Application no: H02-0181-10

Description: Proposed two-storey extension and conservatory

Location: 1 Low Road
Crowland
Peterborough
PE6 0BX

ACKNOWLEDGEMENT OF AMENDMENT

NOTES

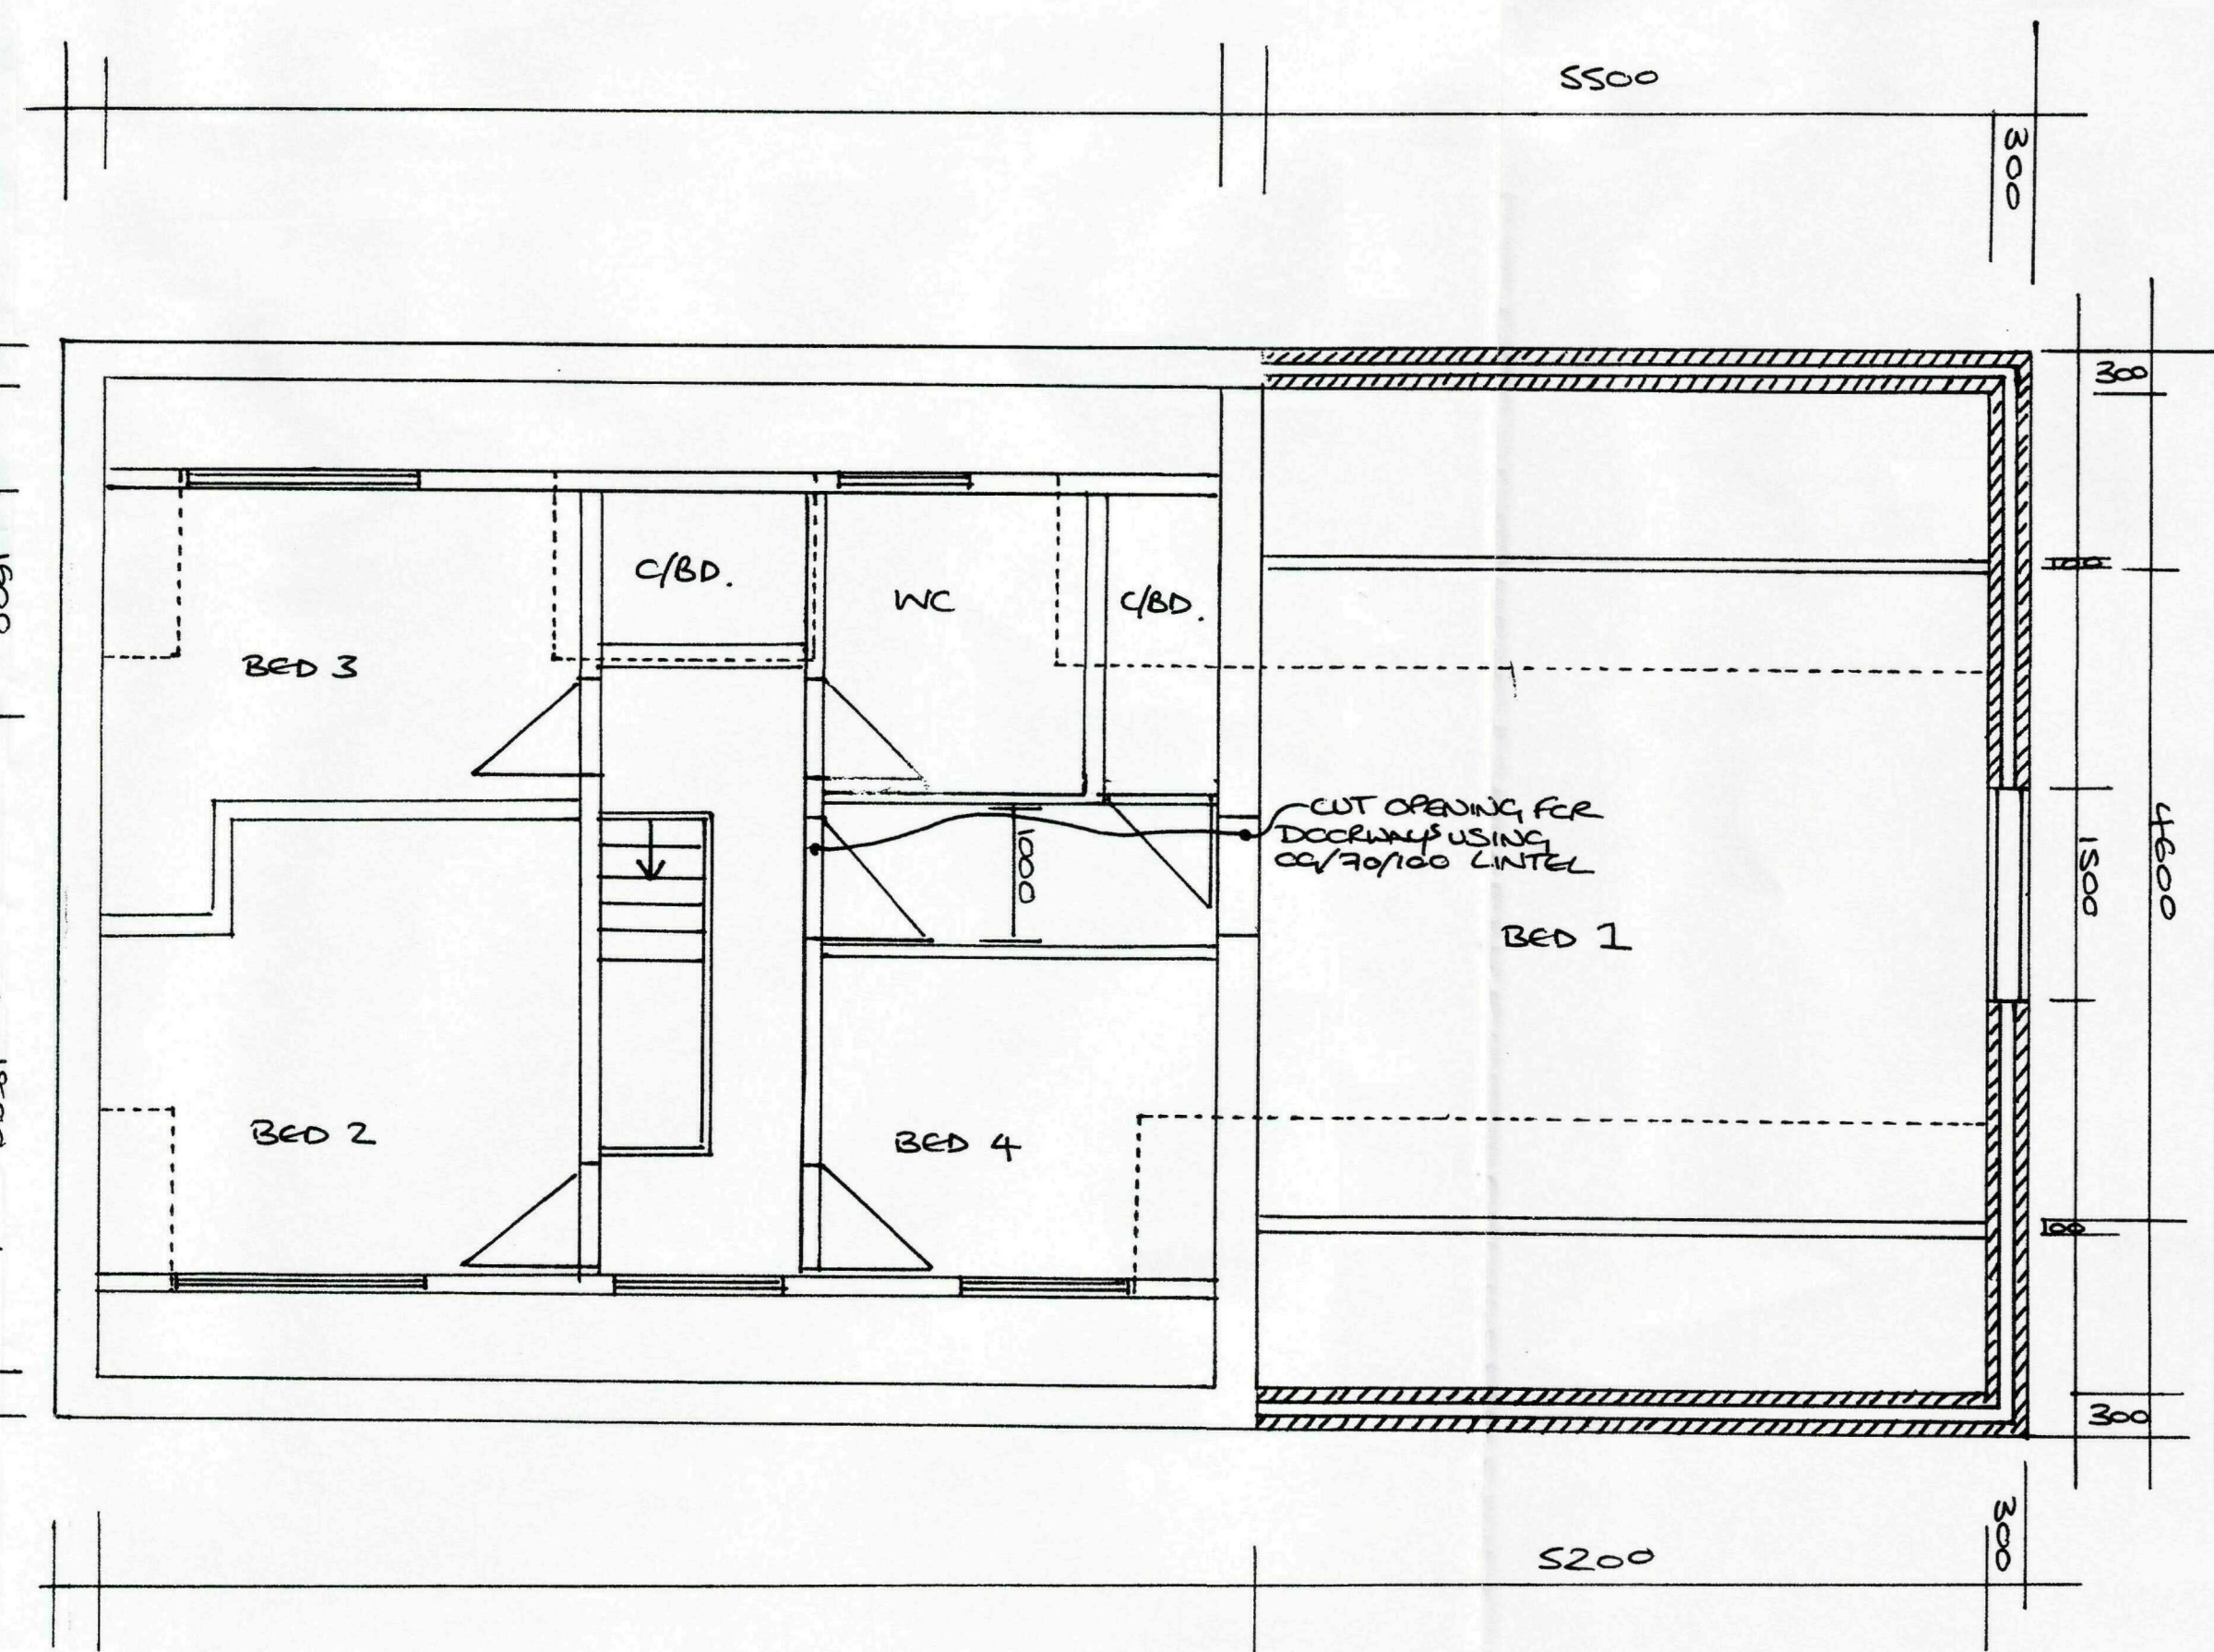
Amendment: Extension to be reduced by 1 metre
(dwg. nos. B/101/A and B/102/A)
